**Consultation Response from KC,
Lead Local Flood Authority**

2024/90425 land south of, Swallow Lane, Golcar, Huddersfield, HD7 4NB

Discharge of conditions 3 (CEMP), 4 (CMP), 5 – 7 (Ground Investigations), 9 (road specification), 10 (footway specification), 11 (road condition survey), 12 (surface water drainage strategy), 13 (construction phase drainage strategy), 14 (arb method statement) and 15 (invasive non-native species protocol) on previous permission 2020/94096 for erection of 21 dwellings and associated works

Date Responded: 12/03/2024.

DRAWING TITLE: SWALLOW LANE, GOLCAR PHASE 2
2.5m Dp. MODULAR WATER
RETAINING TANK
PROPOSAL DRAWING

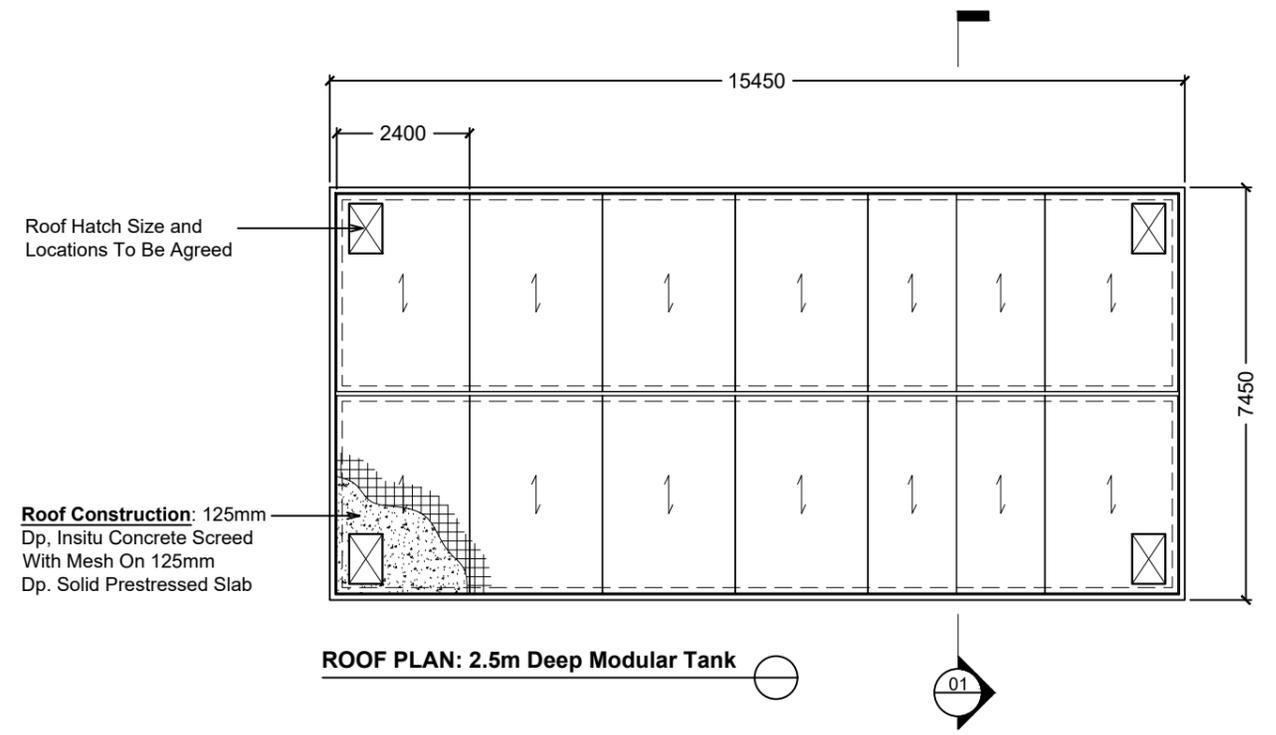
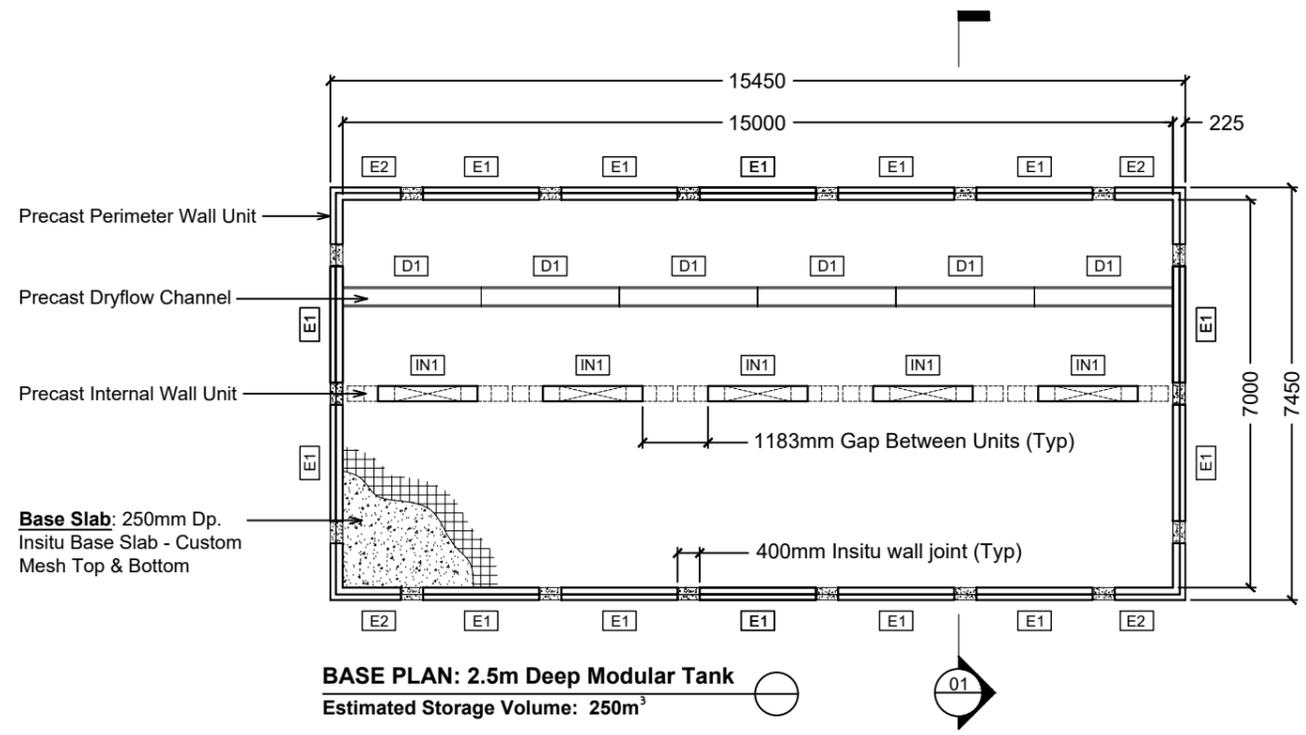
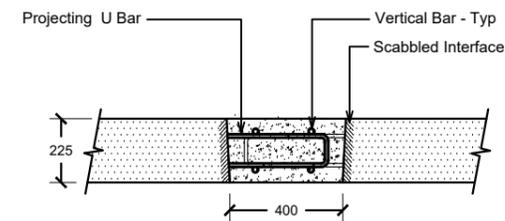
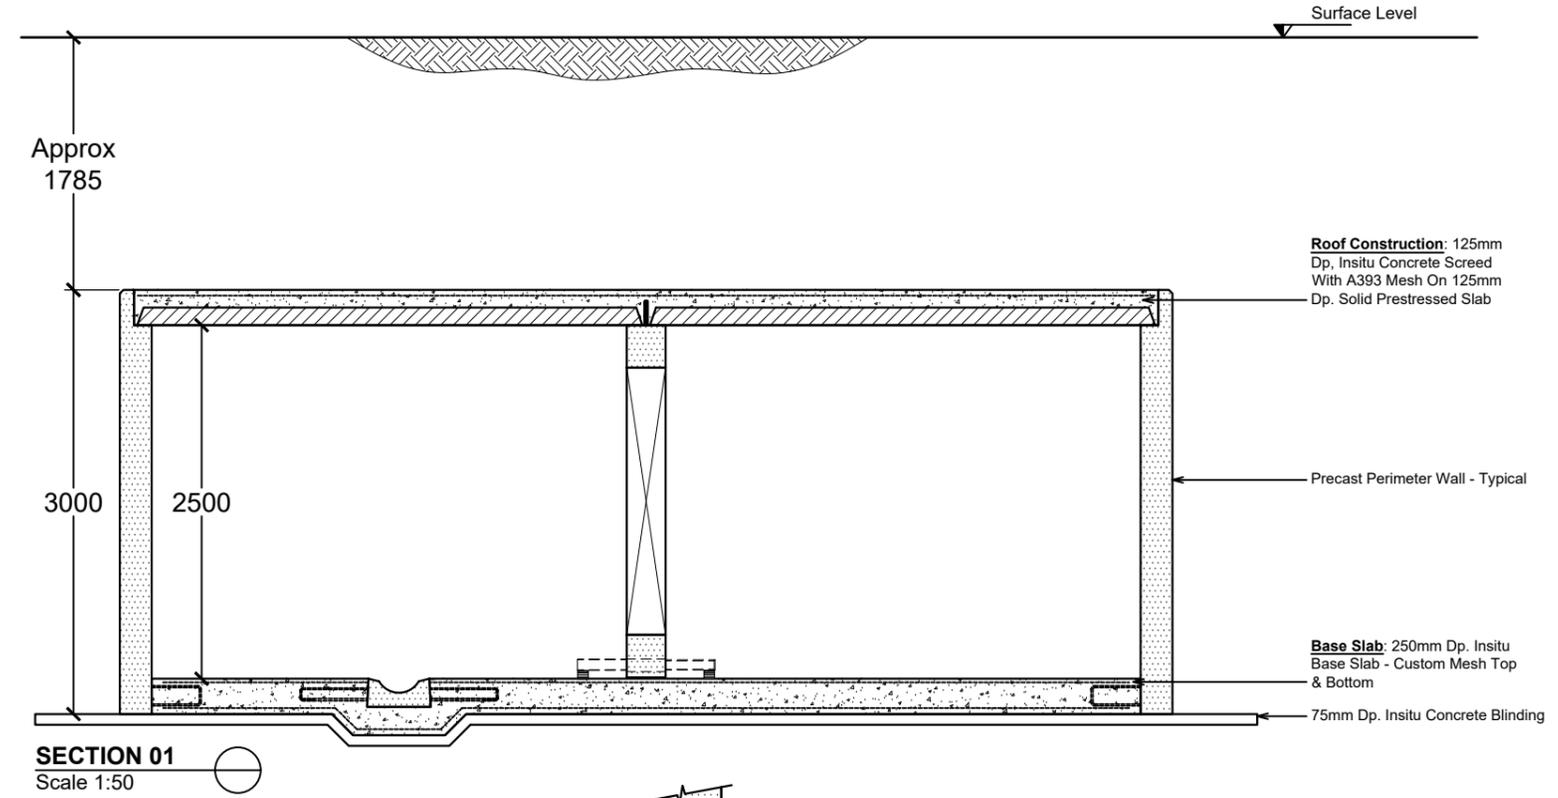
The design head on the HydroBrake is shown as 2.10m in the calculations but the storage tank is 2.5m high, therefore the full volume of the tank will not be utilised. Please provide evidence that there is sufficient storage when the level in the HydroBrake chamber is 2.1m above its invert.

S104-2024-006

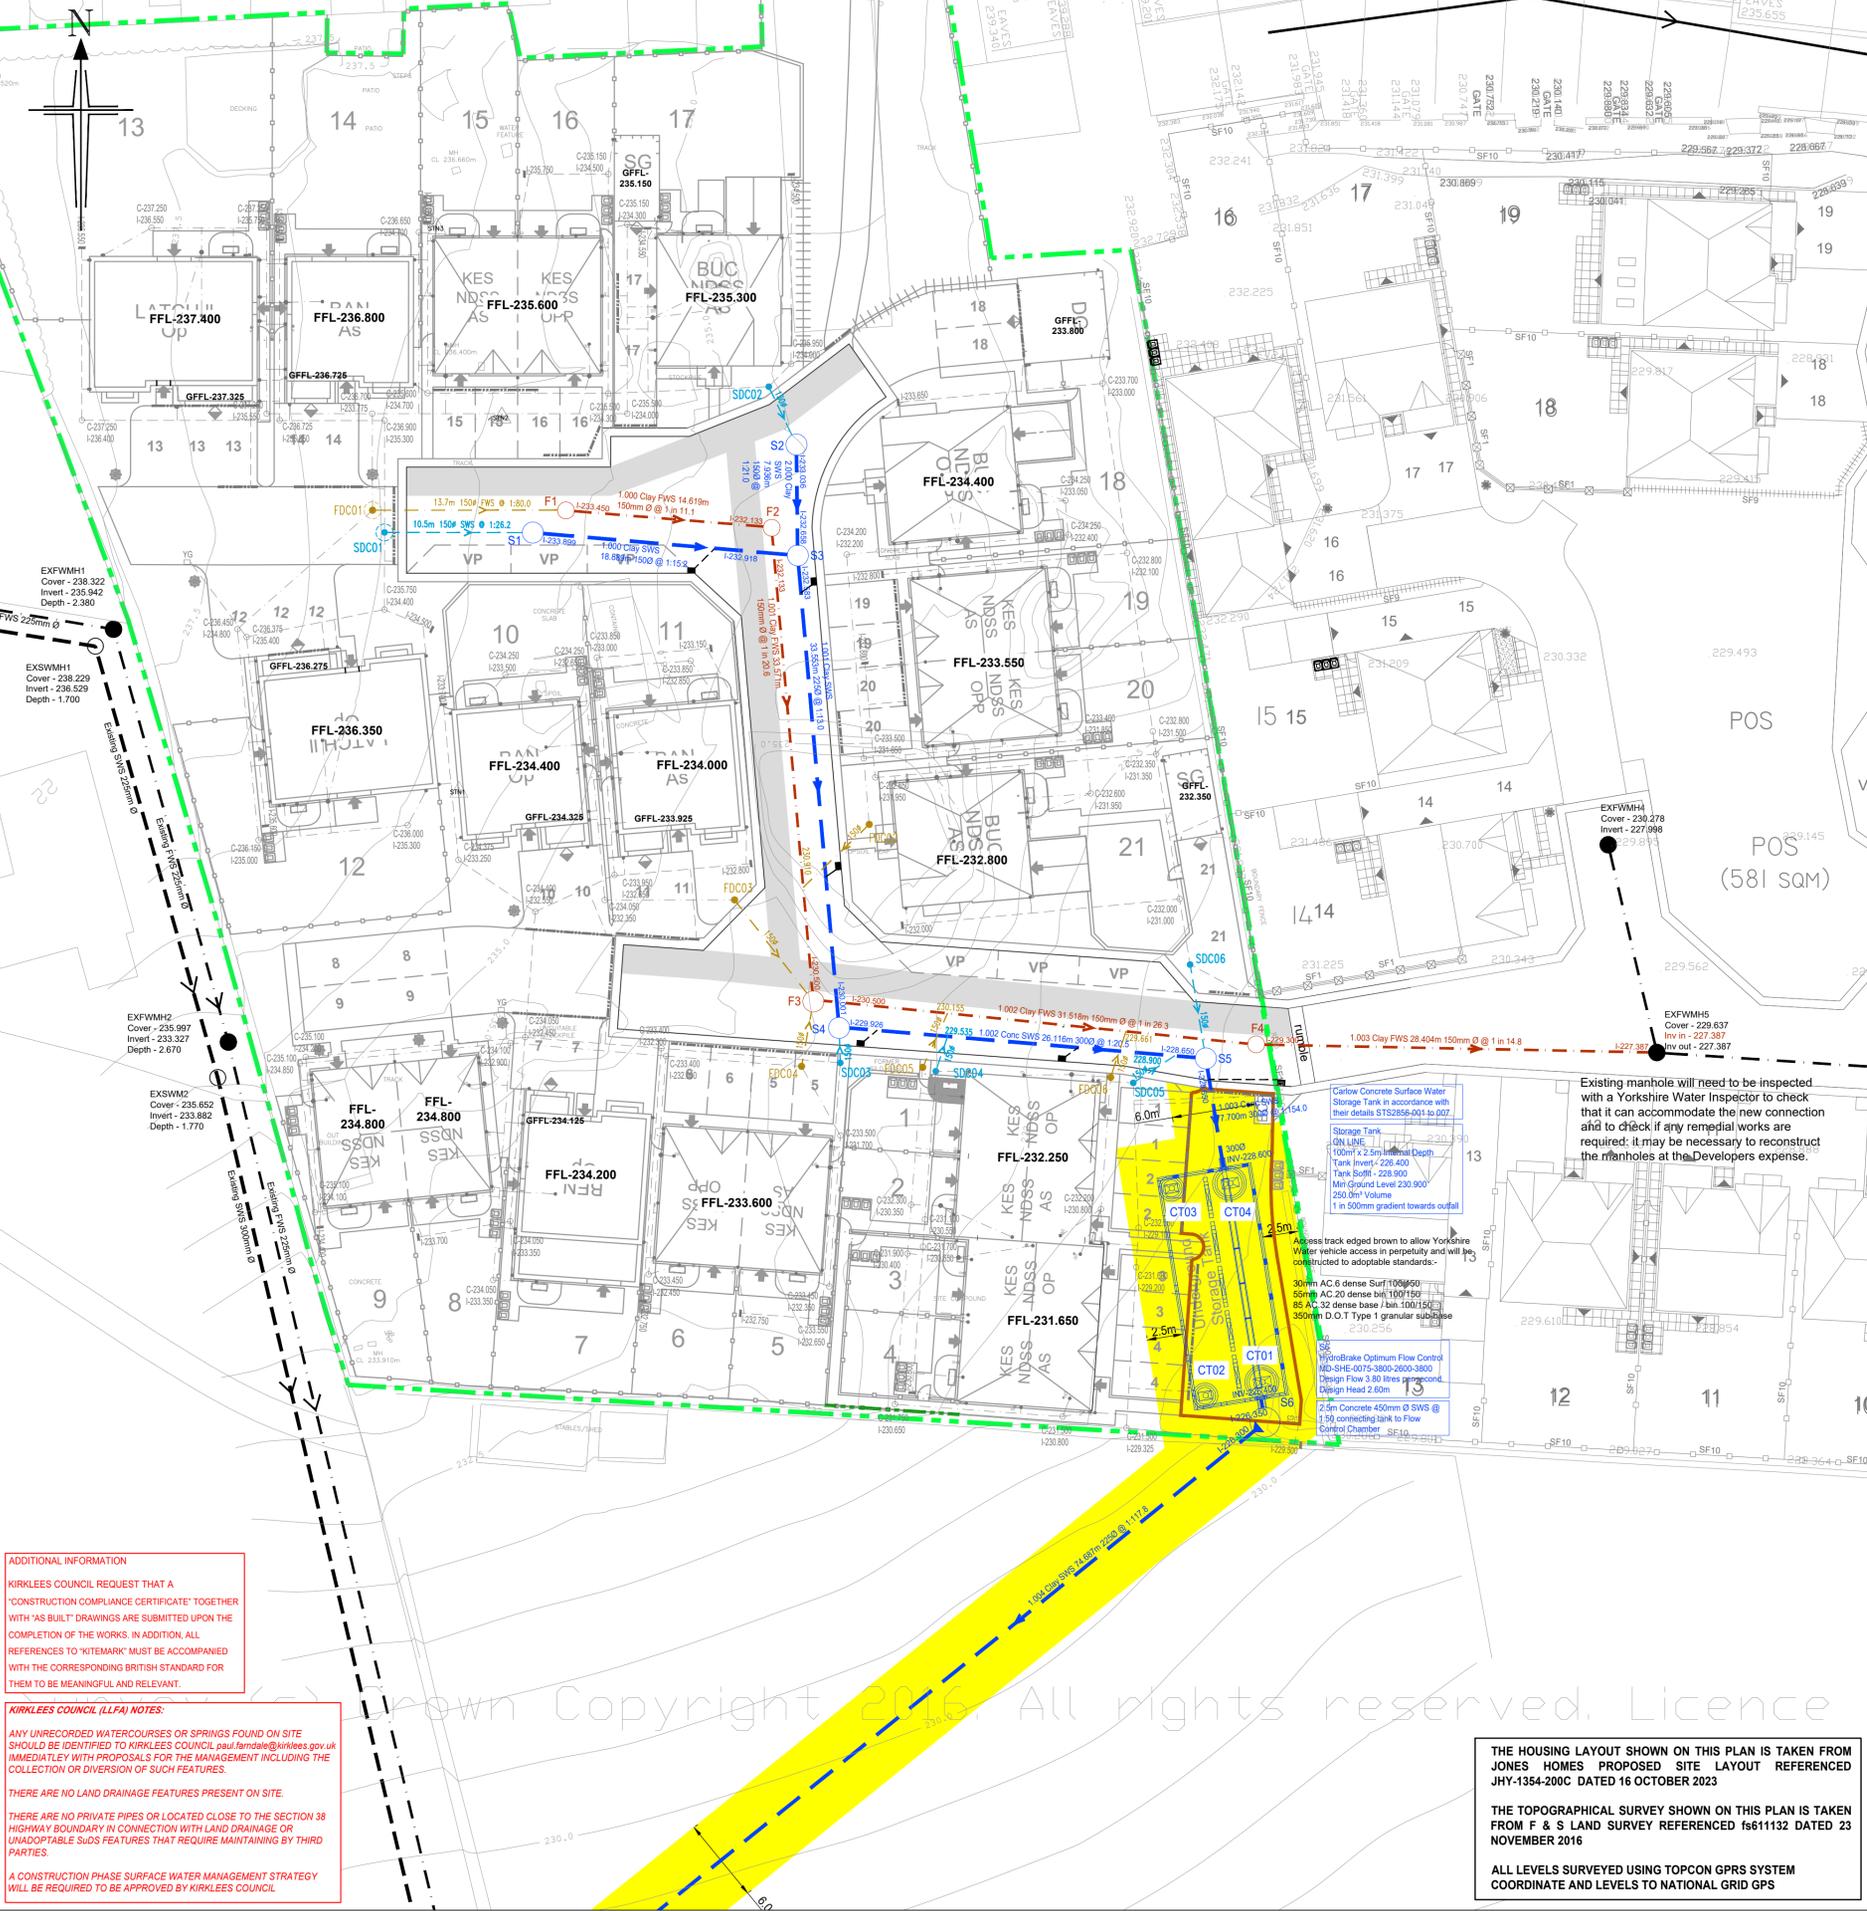
The outfall from the Carlow Storage Tank is shown passing across 3rd Party land – has agreement to cross this land been obtained?

The diameter of the HydroBrake is shown as 64mm diameter on the Drainage Layout and Flow Control MH drawings but as 75mm in the calculations – please confirm which figure is correct.
